Neville Engineering

January 6, 2023

Re: Home for Amy and Daniel Pruitt
Holly Springs, NC

<p>FLOOR PLAN</p>	<p>AMY &amp; DANIEL PRUITT        837 ROLLINS MILL RD        HOLLY SPRINGS, NC 27540</p>	<p>DATED 11/15/22        DRAWN BY        TRUITT BUBB CO.</p>
<p>A-2</p>

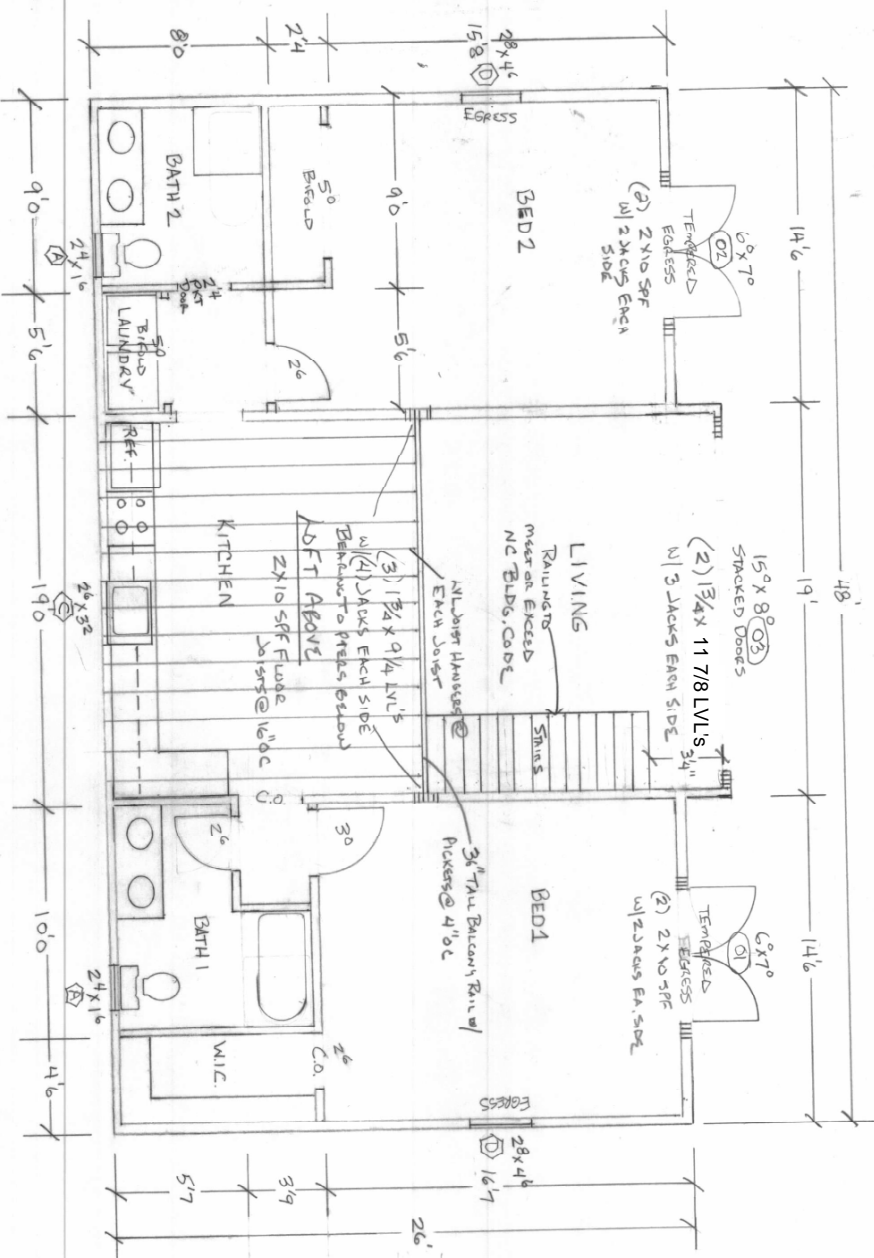
This letter is to confirm that I have reviewed the structural drawings for the referenced project and have only one comment. The double 1 3/4" x 9 3/4" LLV spanning the 15' x 8' doors should be increased to 2- 1 3/4" x 11 3/4" LVL's or to 3- 1 3/4" x 9 3/4" LVL's.
